Application no: 22/03397/DISC

Location: Land To The South And Adj To, South Side, Steeple Aston

Lead Local Flood Authority

Condition 6 states:

SECTION THROUGH 4.5m PERMEABLE BLOCK PAVED ACCESS & PERMEABLE BLOCK PAVED DRIVEWAY
Scale 1:20

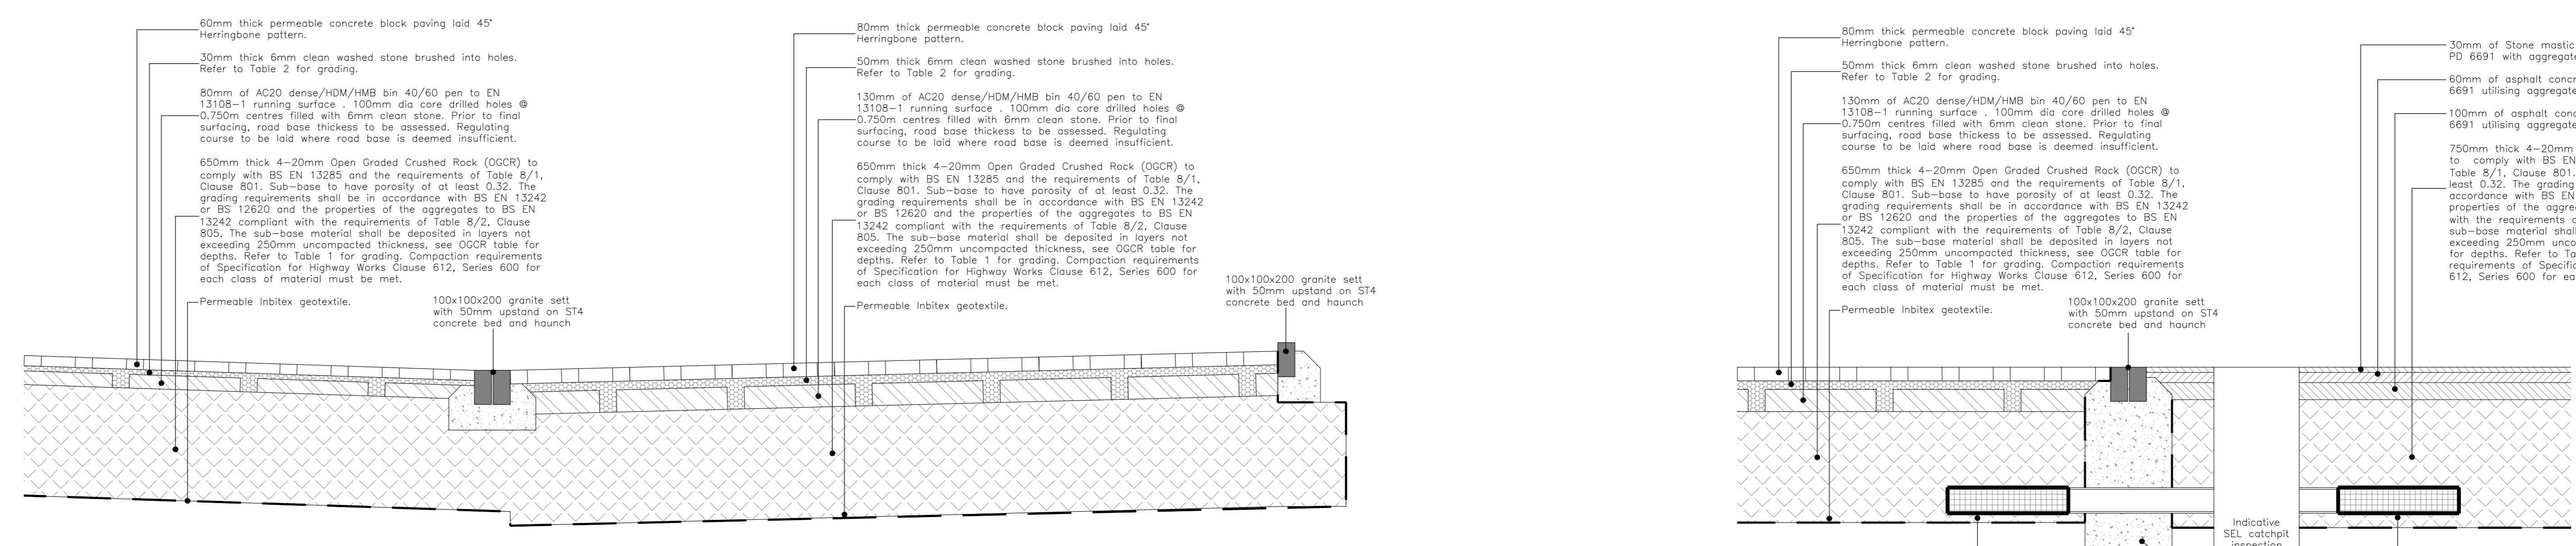
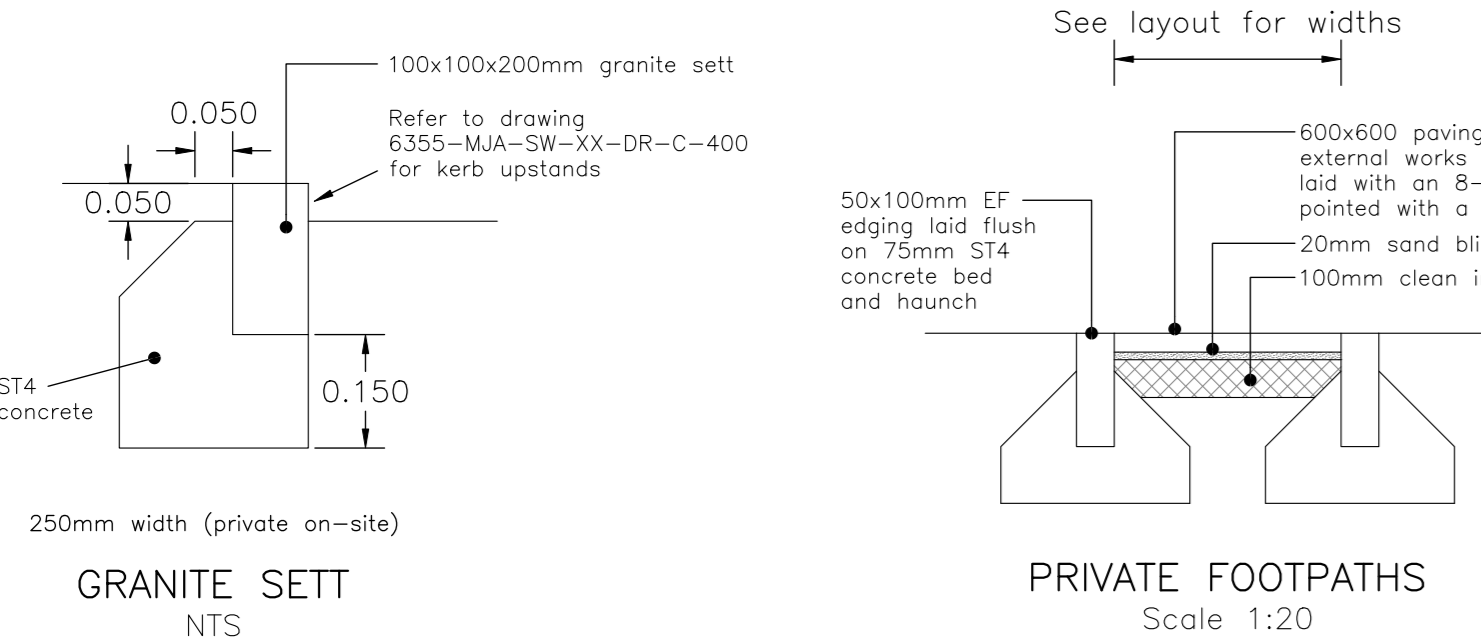
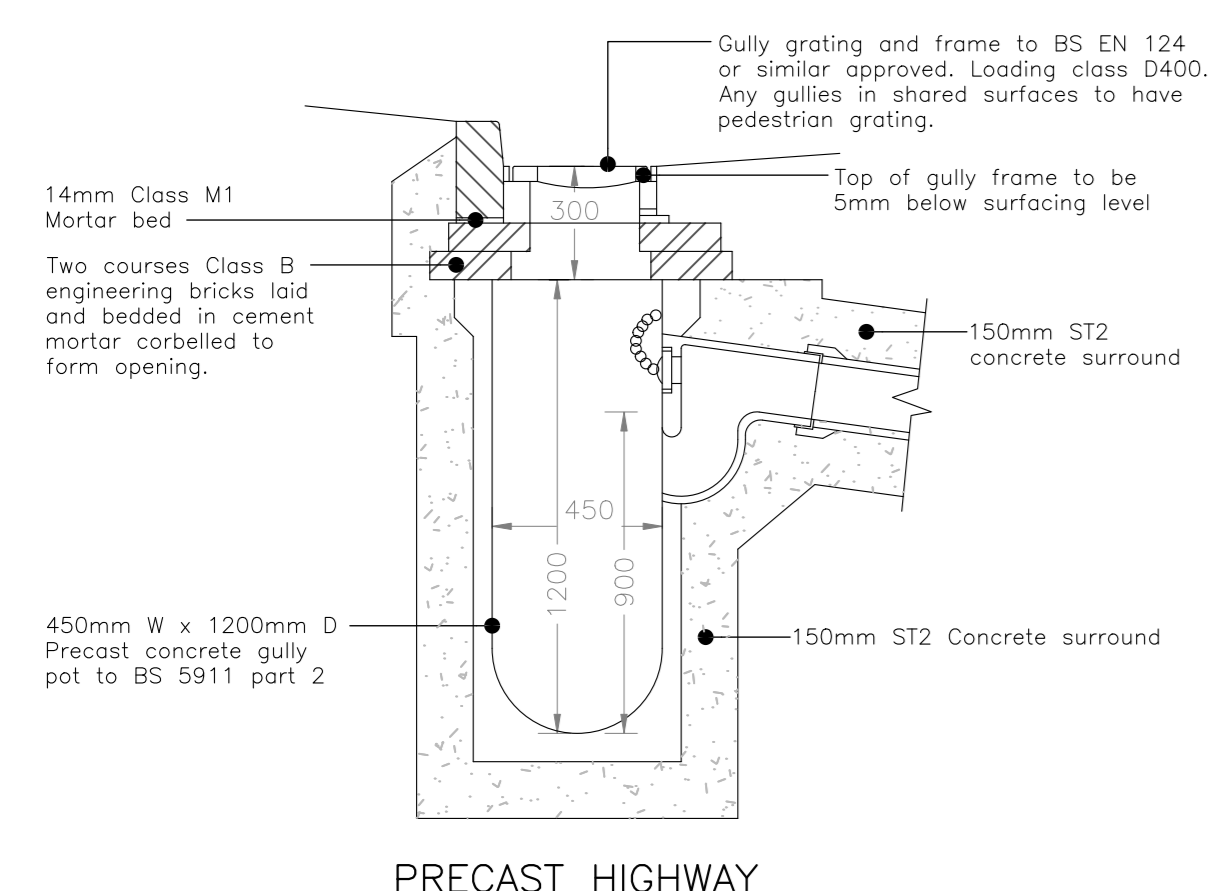
Photographs provided relates to foul drainage. This condition refers to SuDS elements and surface water infrastructure. Laying of permeable paving not provided.
